Your ref:  
Our ref: 23/00237/F  
Please ask for: Luke Swales  
Direct dial: 01553 616865  
E-mail: borough.planning@west-norfolk.gov.uk

16 February 2023

Details: **Proposed single and two storey extension. at Ivy House West Drove South  
Walpole Highway Wisbech Norfolk**

DRAWING NUMBER 533.PD2.01

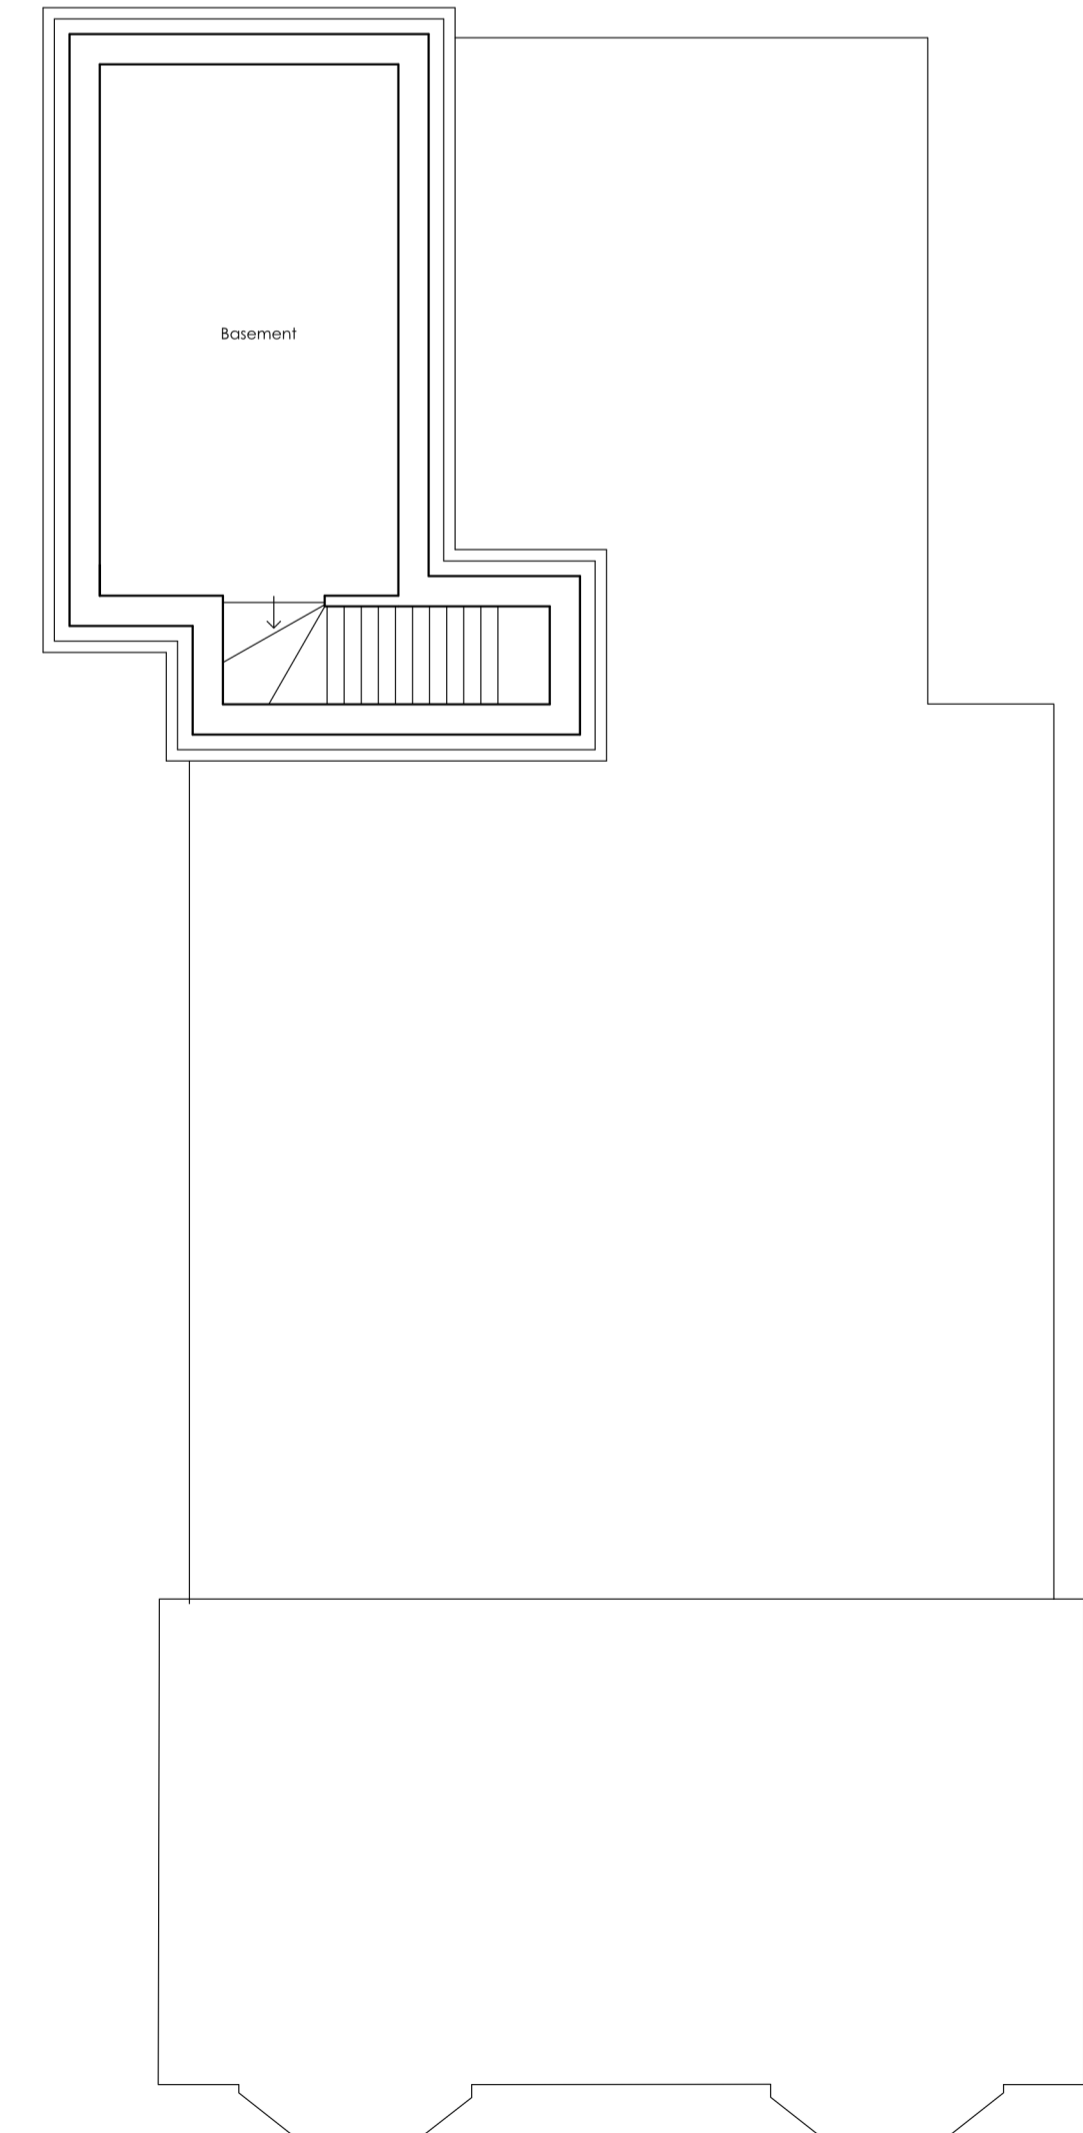
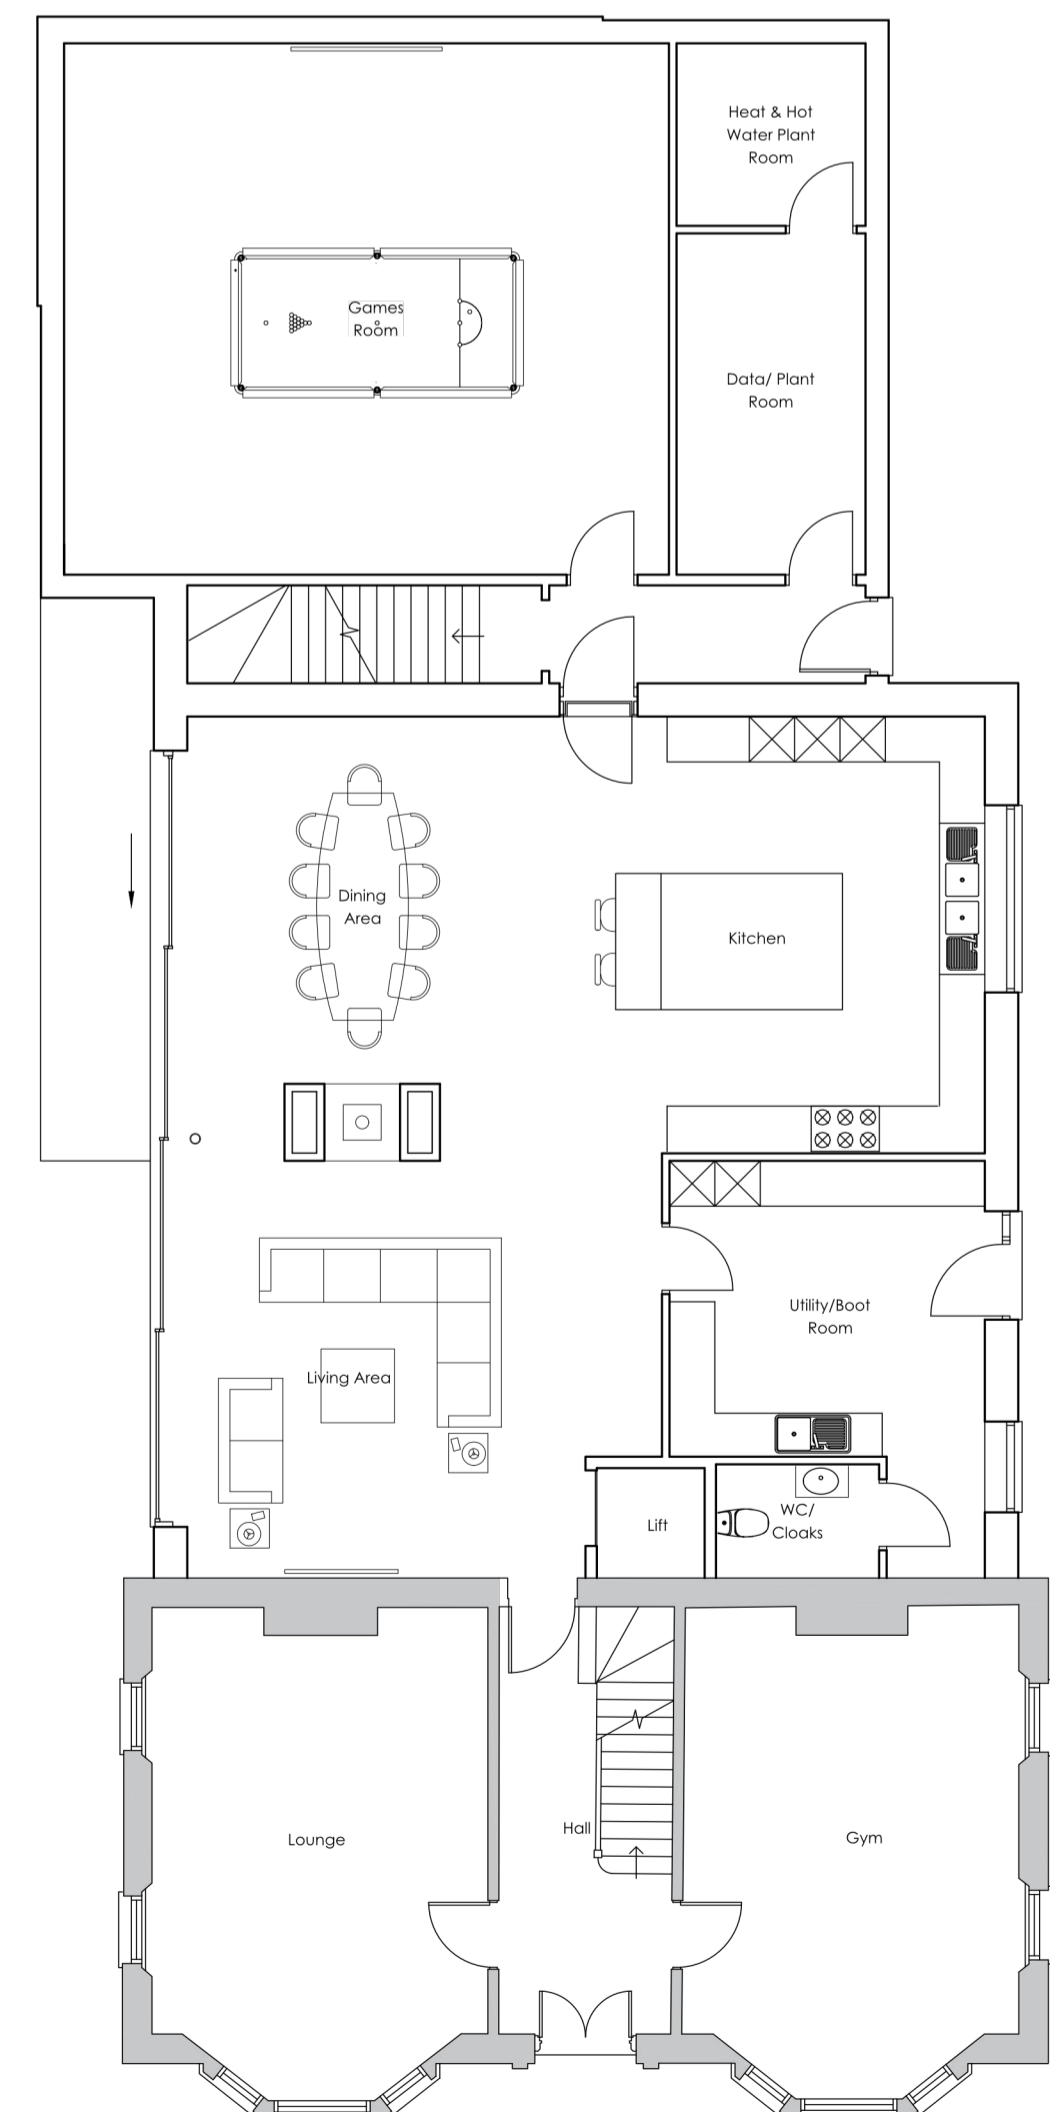
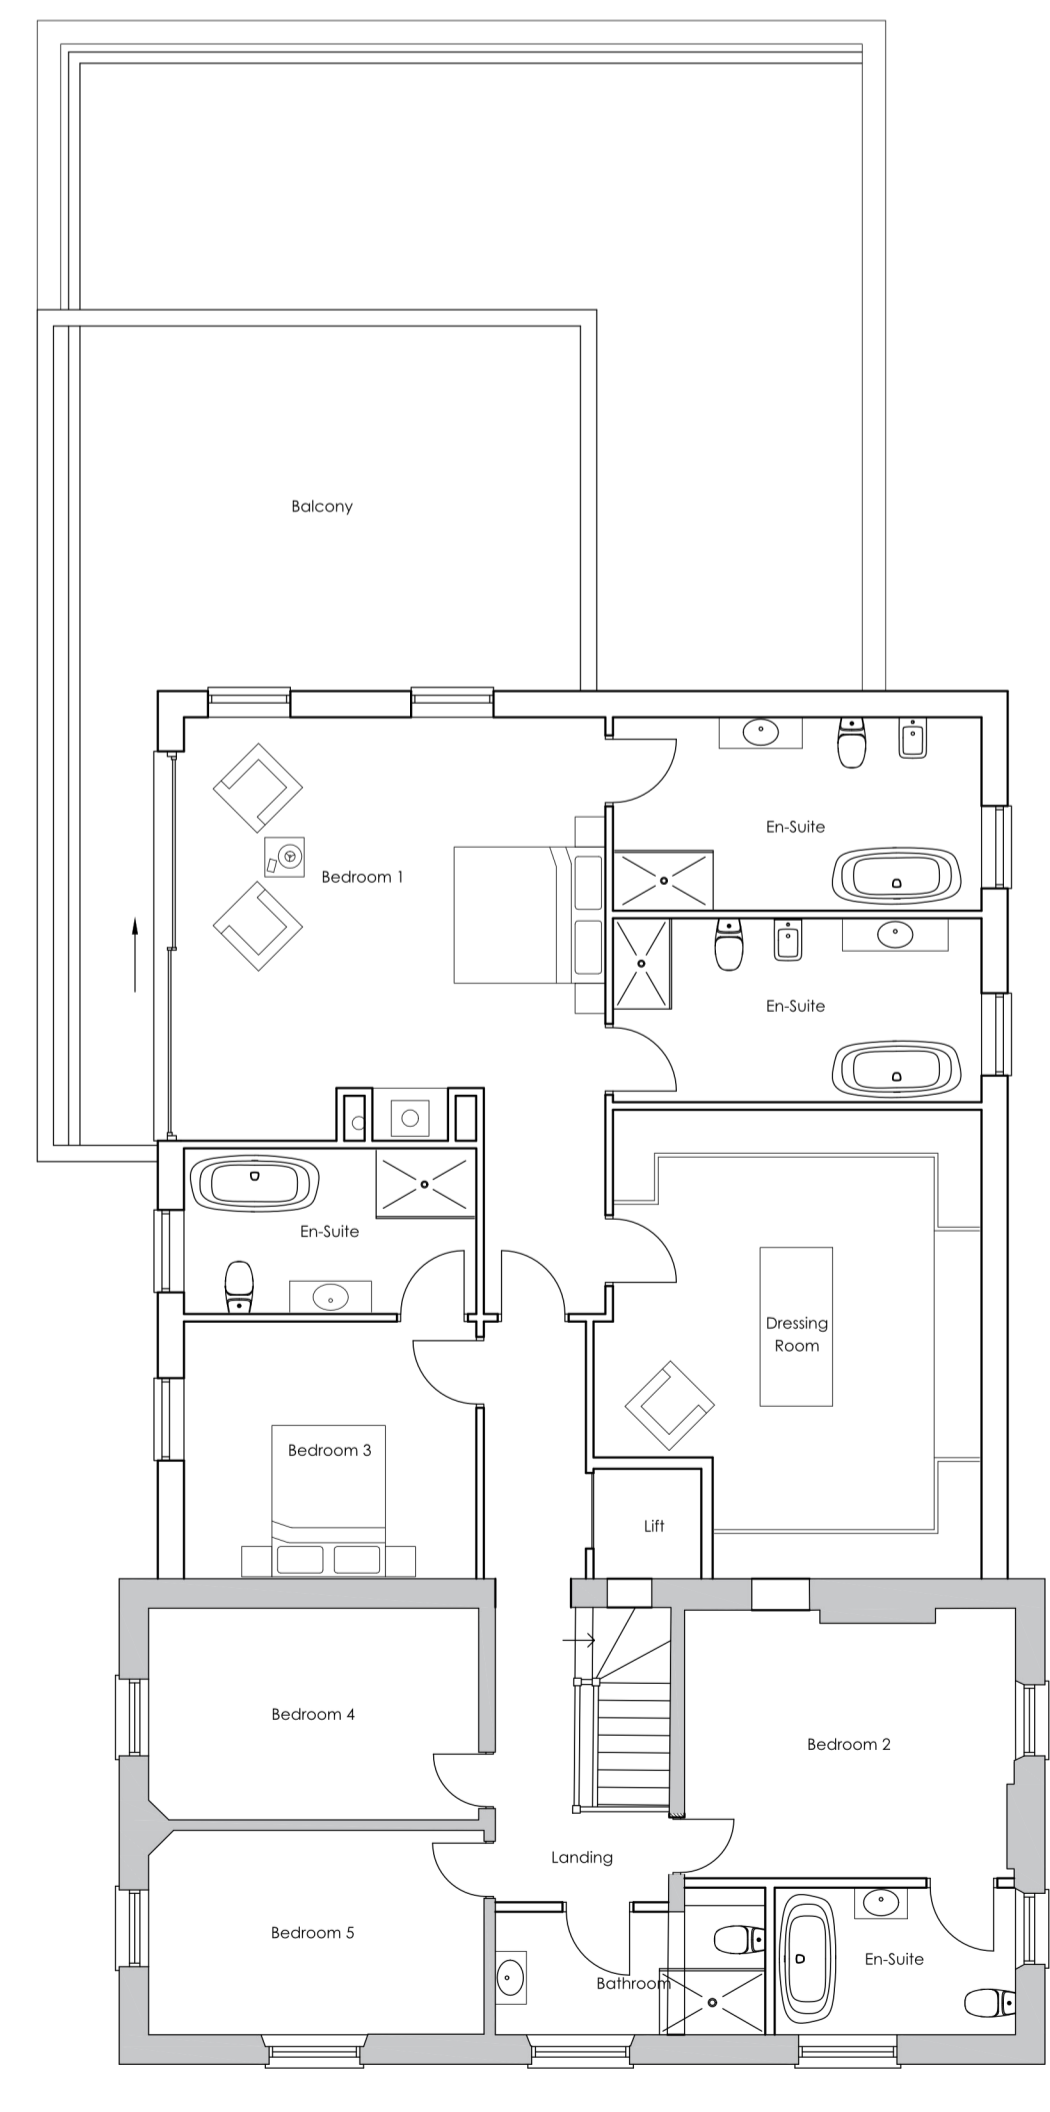
1. Please provide four copies of a drawing, to a recognisable scale, showing a section through the new extension.
2. On your drawing it says "Do not scale directly from this drawing." As part of the national validation checklist all drawings must be true to their stated scales, therefore please amend the drawings to remove this.
3. In accordance with the National Validation Checklist, which became mandatory on 6 May 2008, we will require information regarding site levels. If site levels are to change, please provide four copies of a site survey drawing, alternatively, if site levels are to remain unchanged, this can be annotated on the relevant plan or advised in writing.
4. Please submit a simplified flood risk matrix form. Please put the following on the form: Flood Zone 2, Flood Zone 3A and Other Matters (Dry Island)
